Subject: New comments for application 20/01747/F

New comments have been received for application 20/01747/F at site address: Land South Side Of Widnell Lane Piddington

# Proposed Block Plan

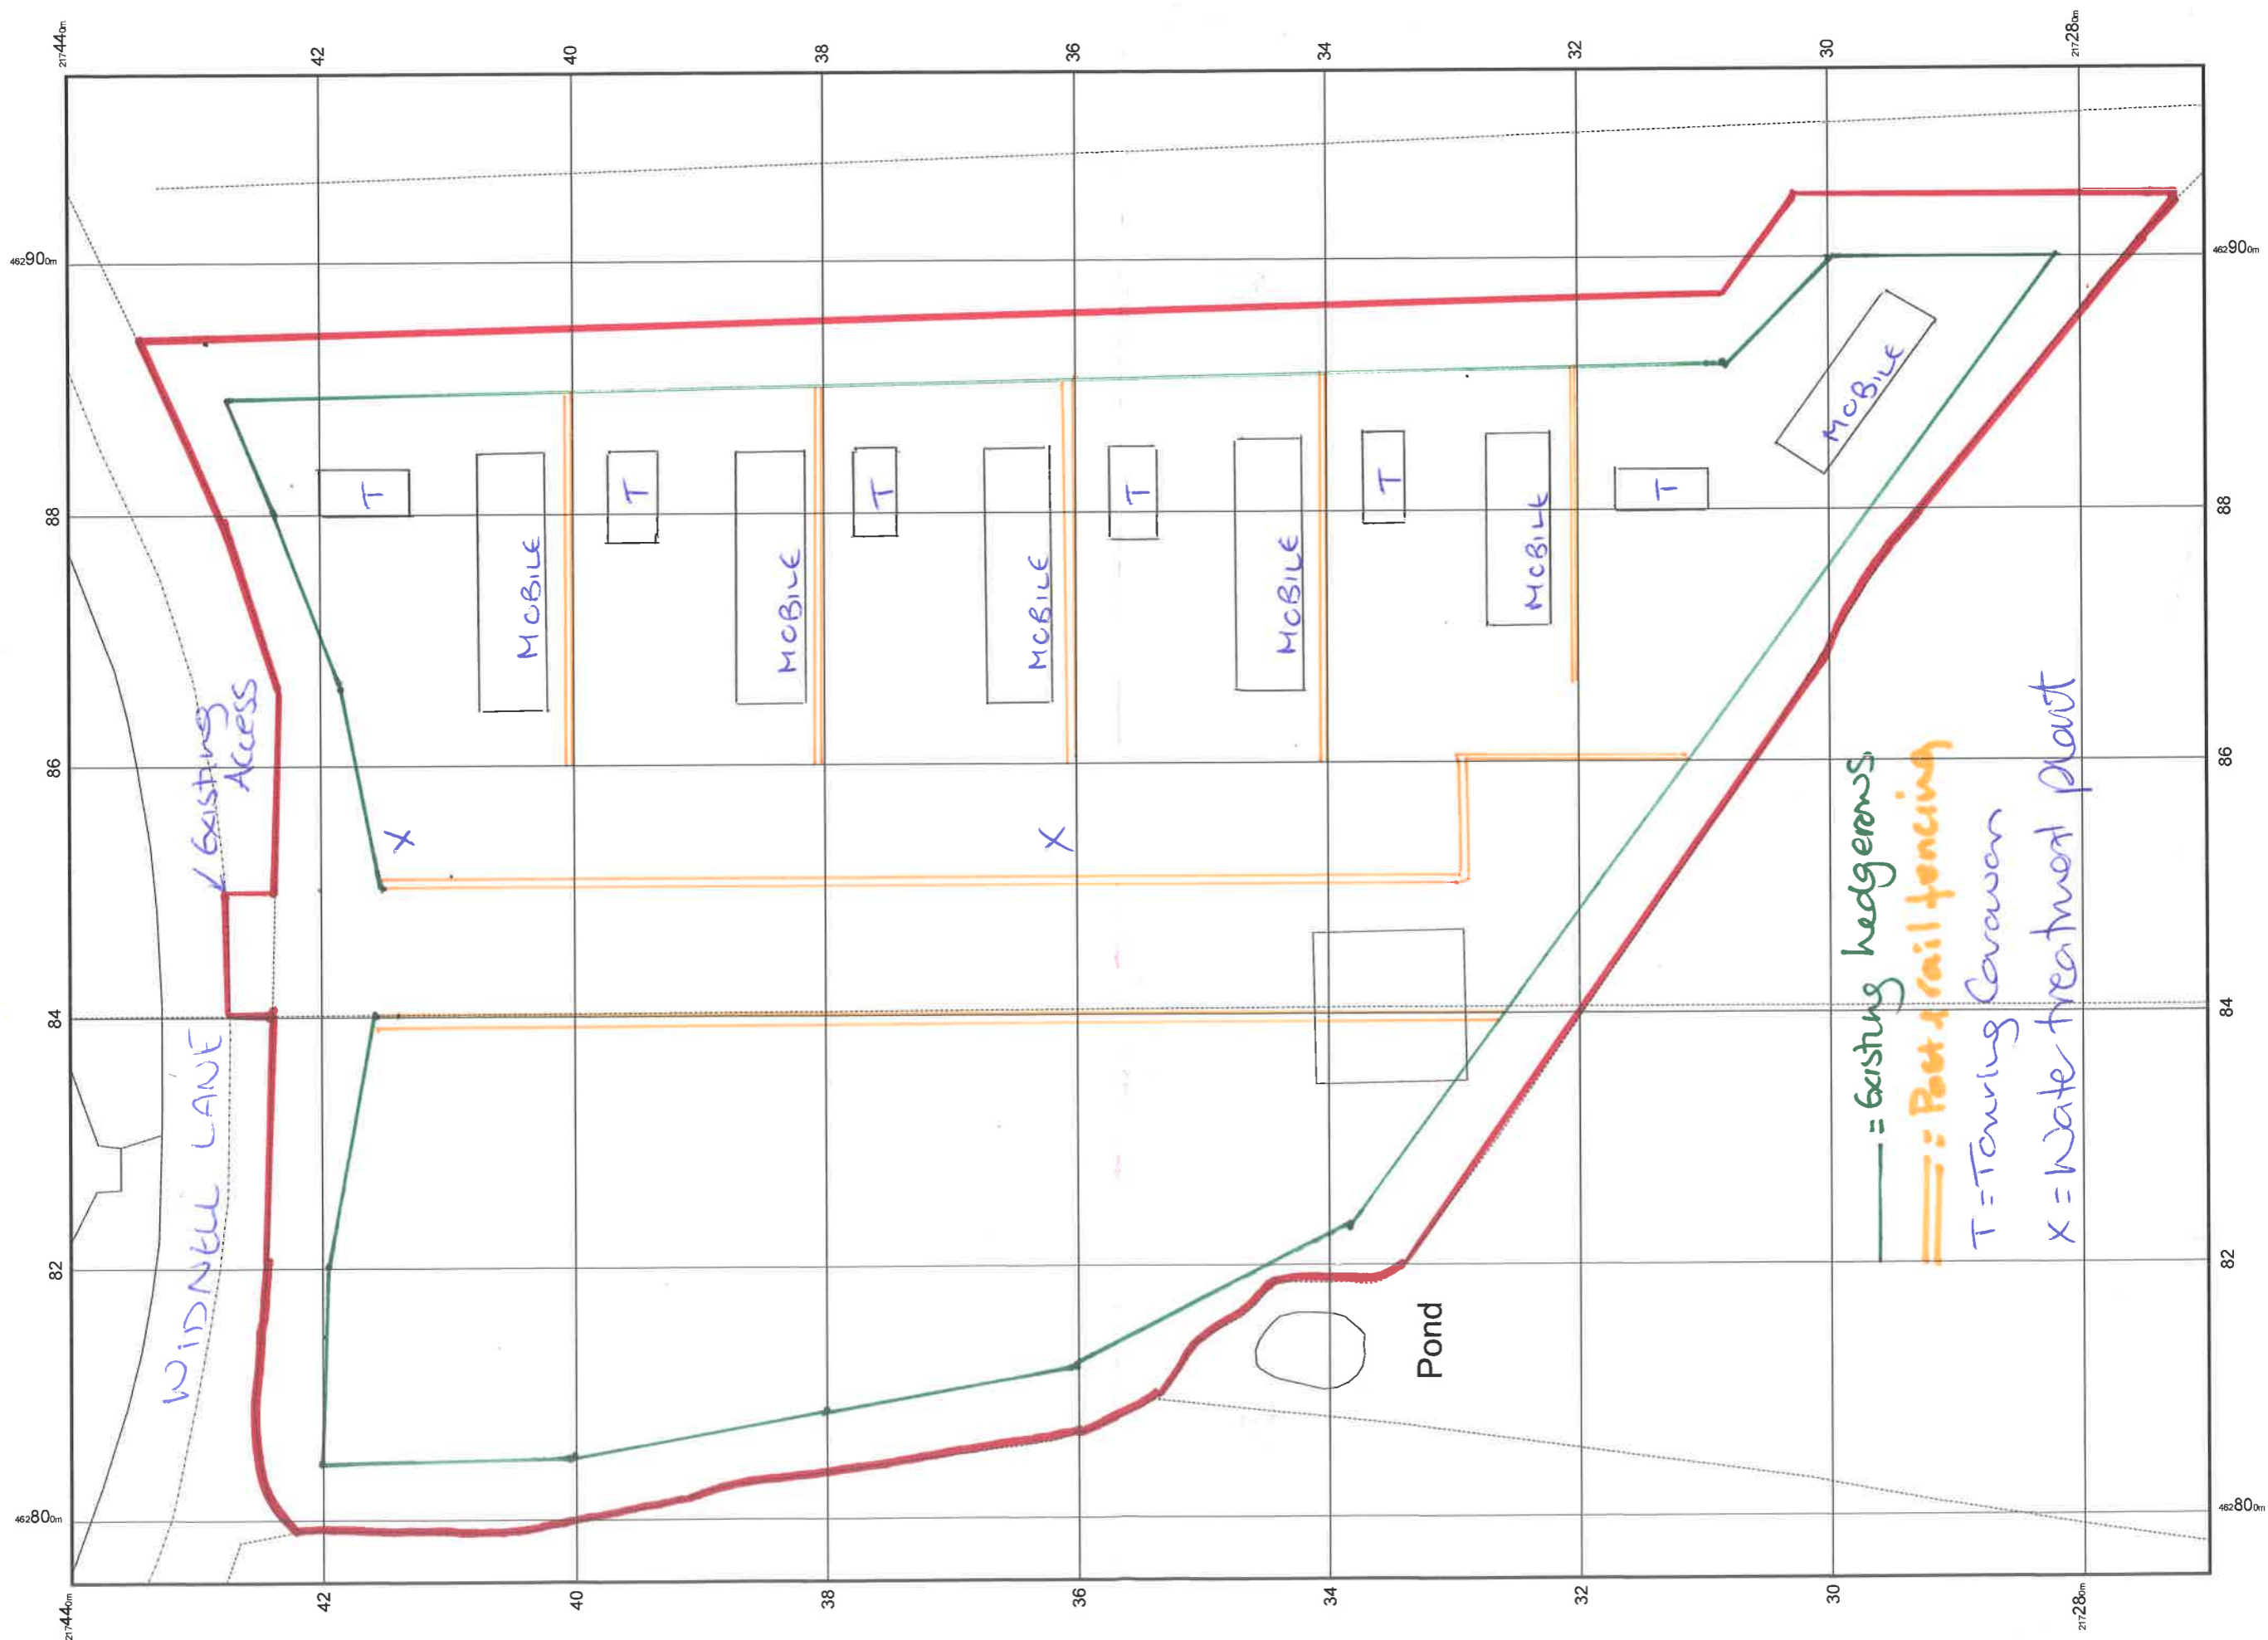
The application in question, 20/01747/F refers to an 'existing' access. Maybe this is a language I am not privy to because when I study the plans it is quite clear that there is no such access excepting that provided for by the application for the adjacent encampment of 20/01122/F. Nothing new there then.
